CM/8/21/PL

Climping College, The Mill, The Mill Lodge, Climping Street, Climping

*Construction of site perimeter bunding & associated planting to protect against flooding,
associated excavation of a pond (retrospective) & construction of flood defence gates
(resubmission following CM/25/20/PL)*

Martyn White
Principal Conservation Officer,
Planning Services

corten flood wall and gate
CM_flood wall + gate
Scale: 1:100 + 1:50 @ A2
Date:18.01.2021

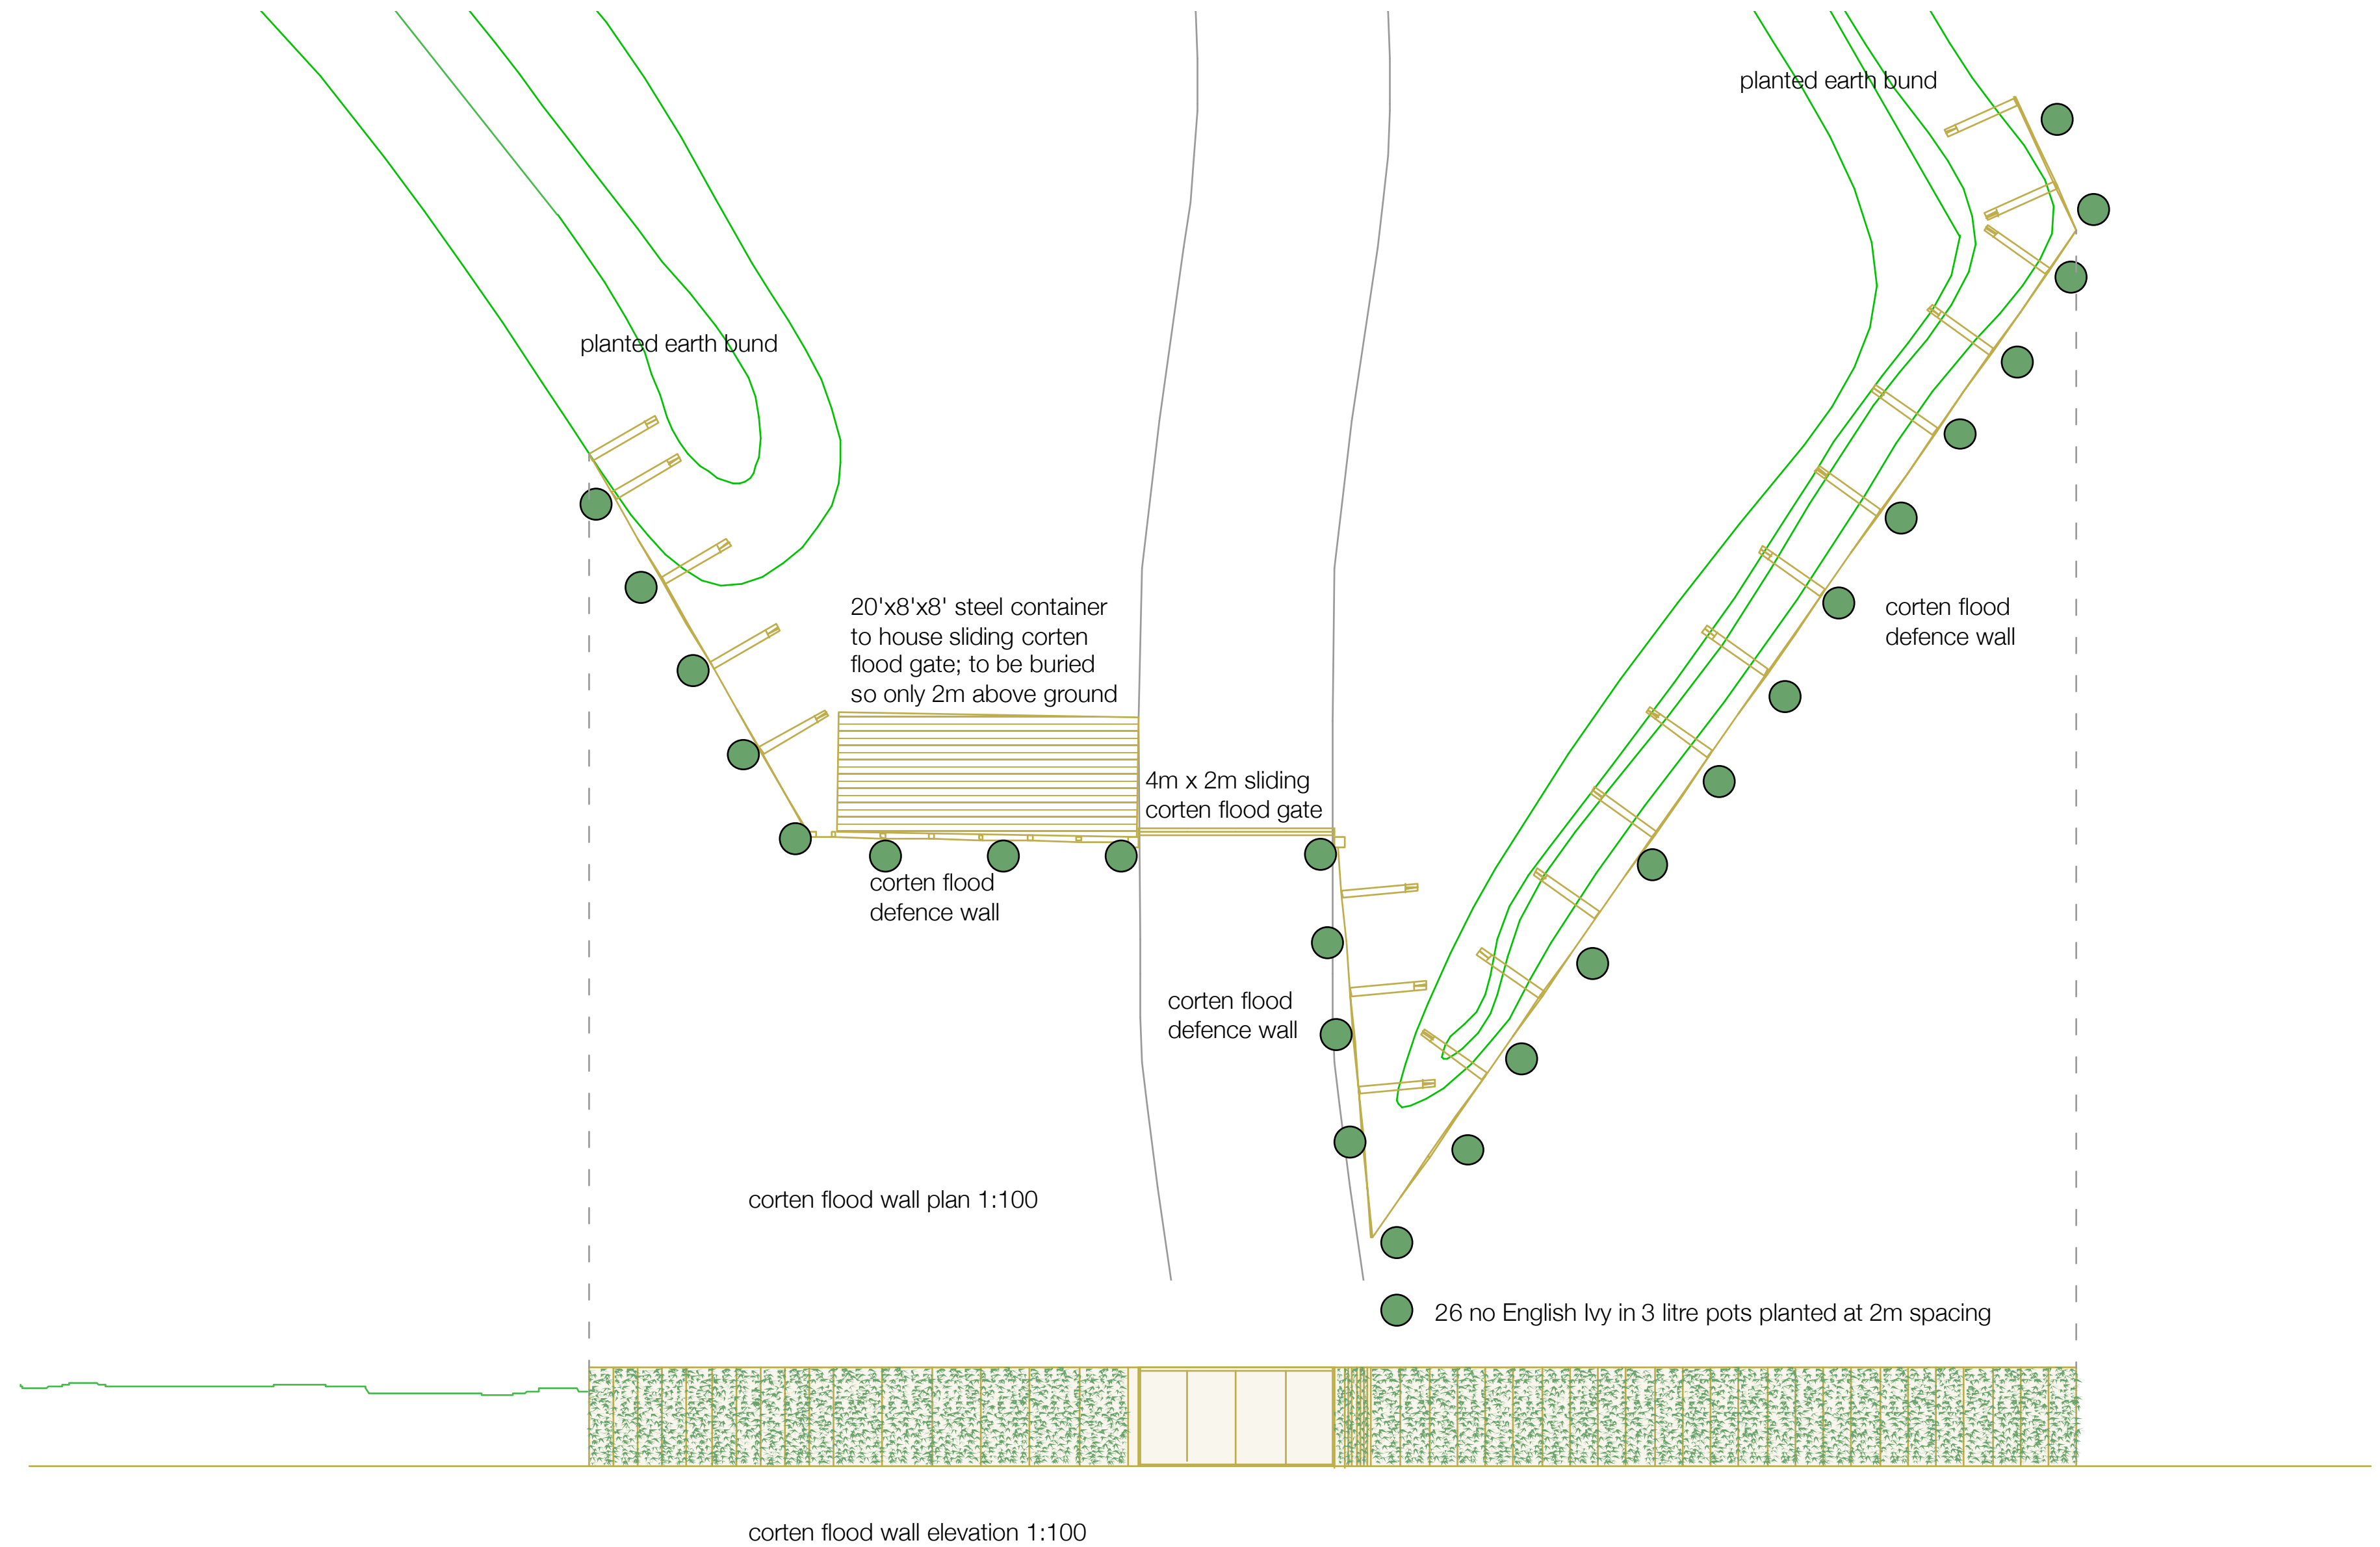
The new gate and fencing, are more of an obvious introduction to the site (due to their size, material and appearance), but their reason is understood. The gates are of a design, size and material which would mean that would have much more of a visual presence, when compared to the earthen bunds.

The location is some distance away for the listed buildings and somewhat screened by existing vegetation. Whilst I note that some of the trees (especially elms will be removed, it is also positive to understand that new trees are to be introduced as part of a Sussex Wildlife Trust partnership. However, as noted in the heritage statement this element of the proposal would impact upon the overall setting of the mill complex, by segregating it from the landscape on an historically open approach.

It would appear that the design approach undertaken seeks to reflect the exposed nature of the site. The material are also seen further along the coast in Littlehampton.

As part of my consultation commentary for the previous application I suggested that this could be improved through the introduction of further planting, which would help to soften the impact, especially from the elevation as you drive up to the site. It is positive to note that this suggestion has been considered. Such a landscaping element should be designed so that the large areas of exposed metal would be quickly hidden from view. However, as identified in the heritage statement, this element of the proposal could be harmful on the setting of the heritage asset, even if it is to a limited degree.
